**MP10\_0171 Mixed Use Residential, Retail and Commercial Development, at 330 Church Street Parramatta**

Matthew Webb  
Manager Strategic Asset Management  
Network Development  
In reply please quote file no.: 2011/00095/001

02 PLAN - EAST TOWER
1:100

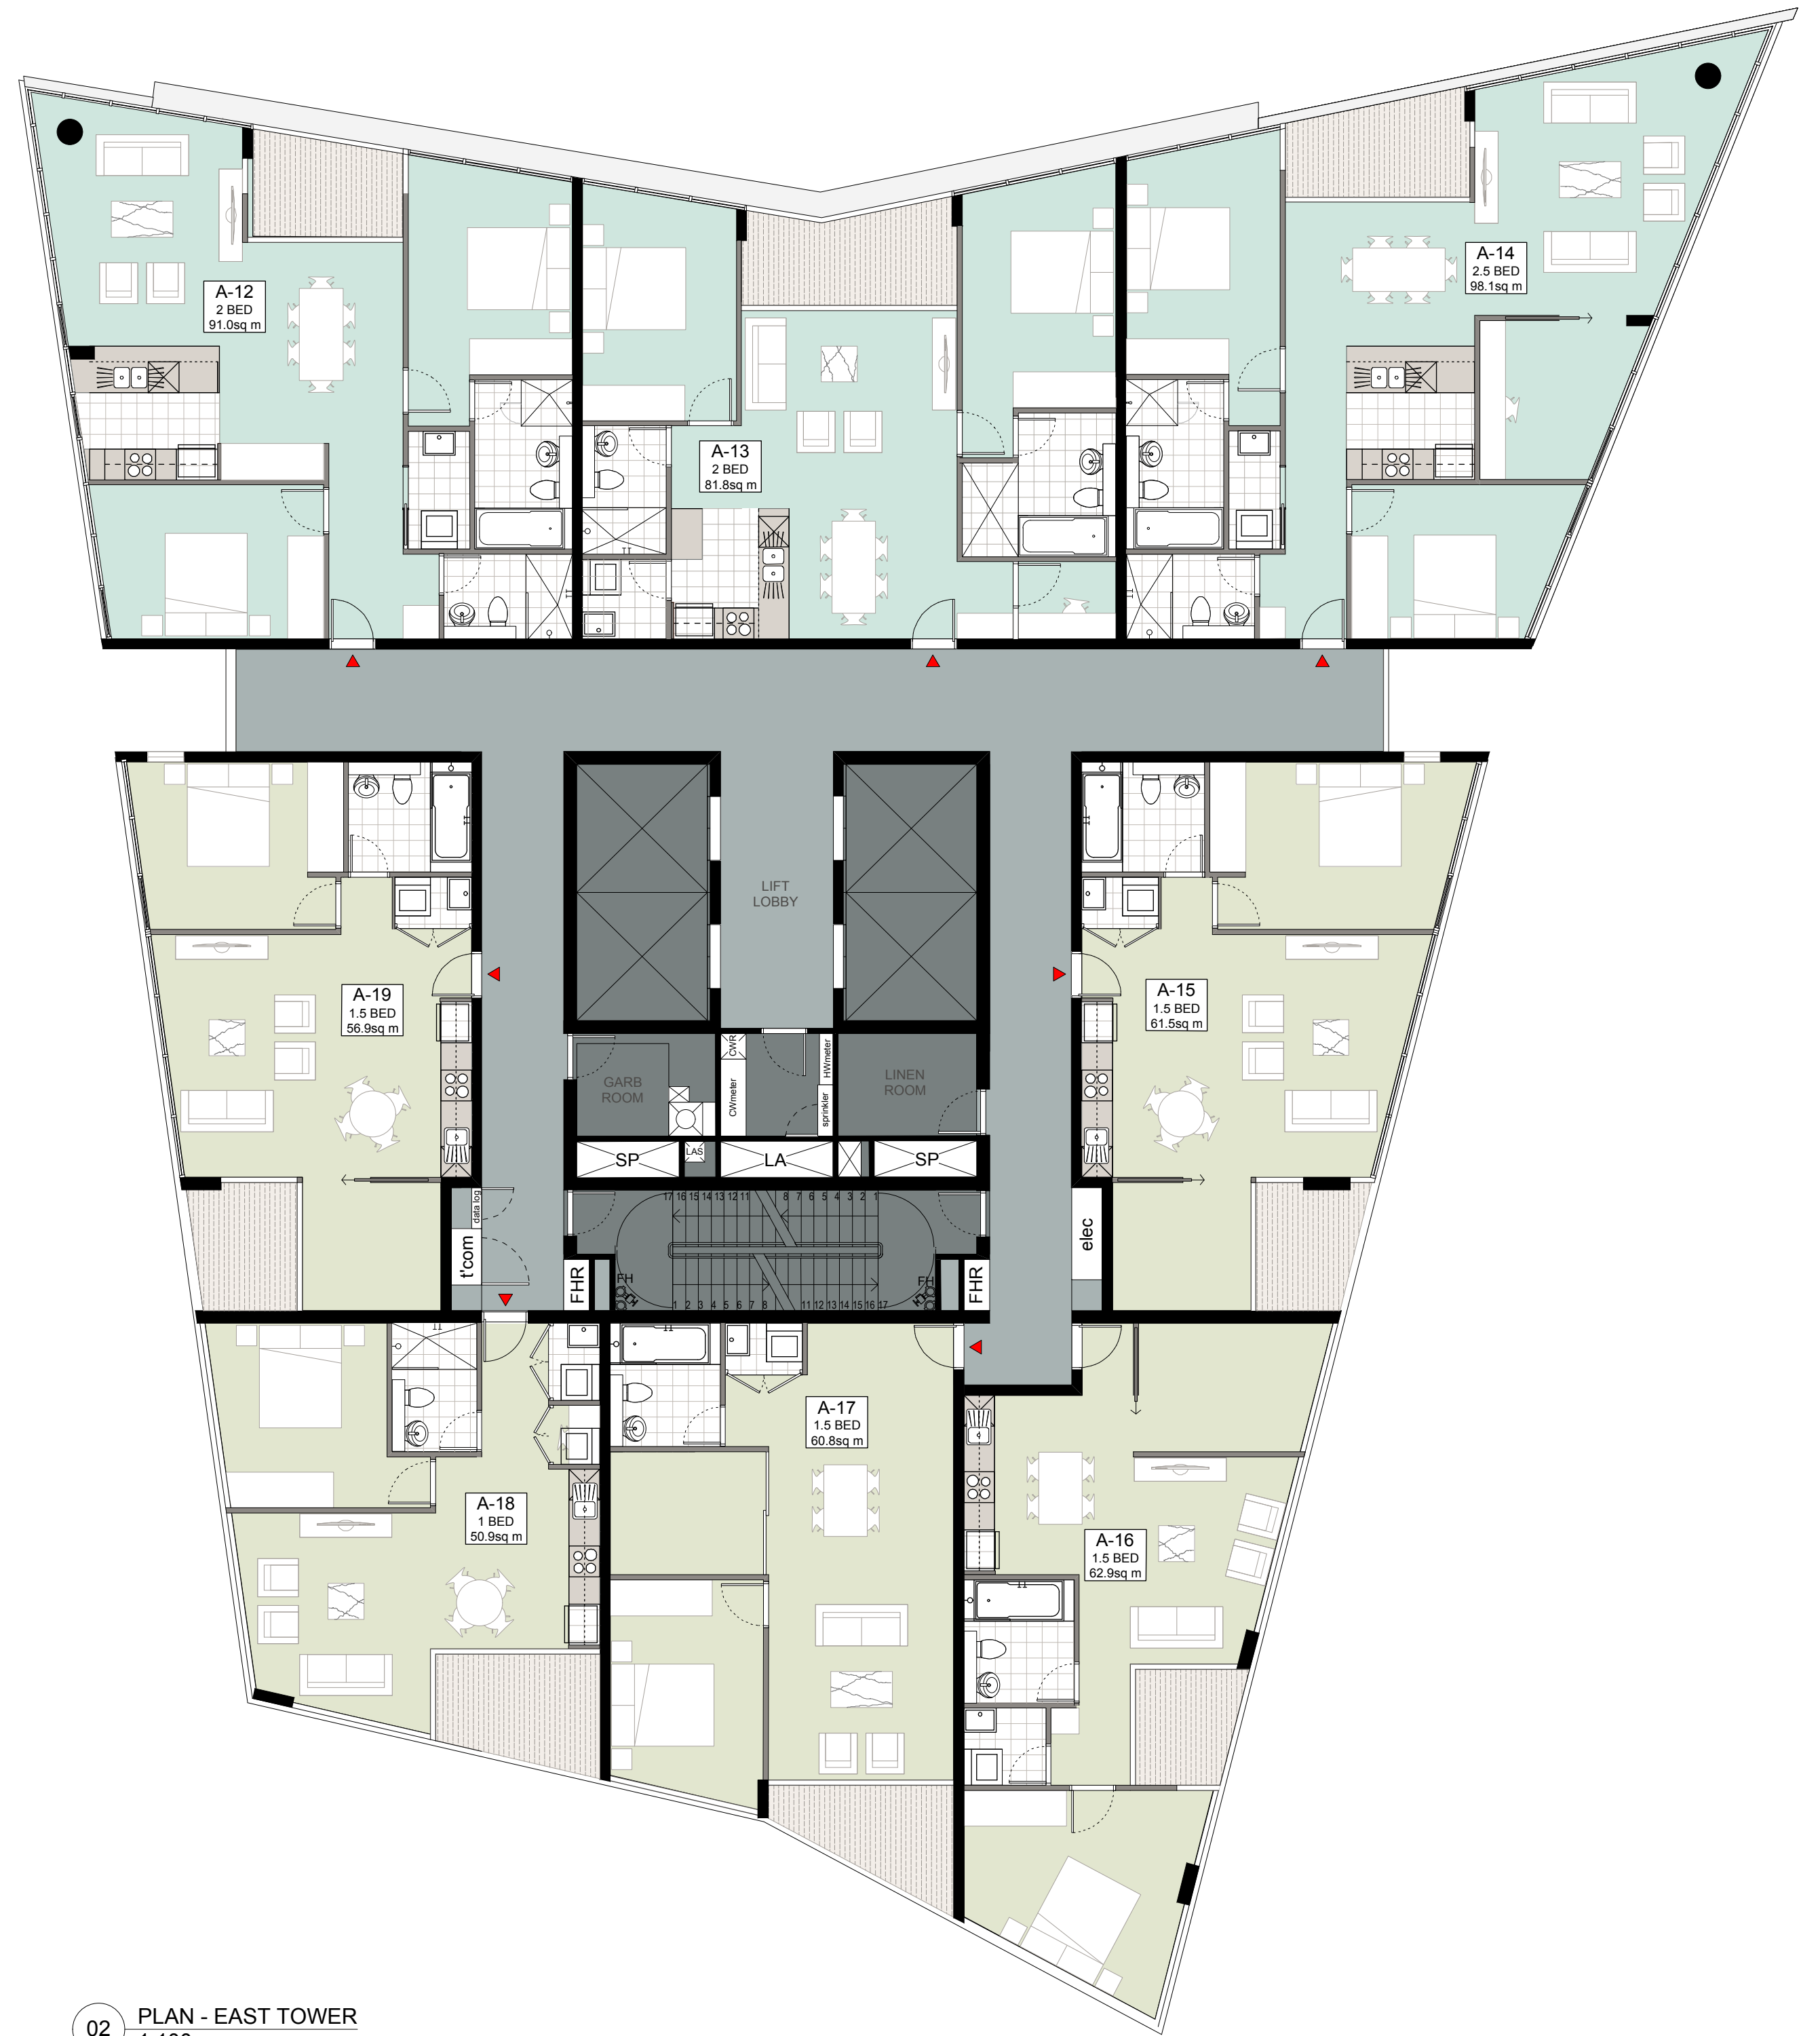
The proposed development is currently on a site serviced by an Endeavour Energy indoor substation (1841) which supplies the existing vacant building.

The applicant's proposal shows a new indoor substation within the East Tower development of this site. It appears from the applicants plans that the existing substation (1841) would need to be demolished to enable the development to proceed. There are also associated easements over this existing substation which would need to be extinguished.

This new development is likely to have a significant electrical load requirement.

Accordingly, it is essential that prior to approval of this development, the developer makes arrangements for electricity supply with Endeavour Energy. This will enable a determination of a suitable size indoor substation room for the ultimate electrical load of the new site as well as the available electrical capacity in the Endeavour Energy network and any other requirements that may apply.
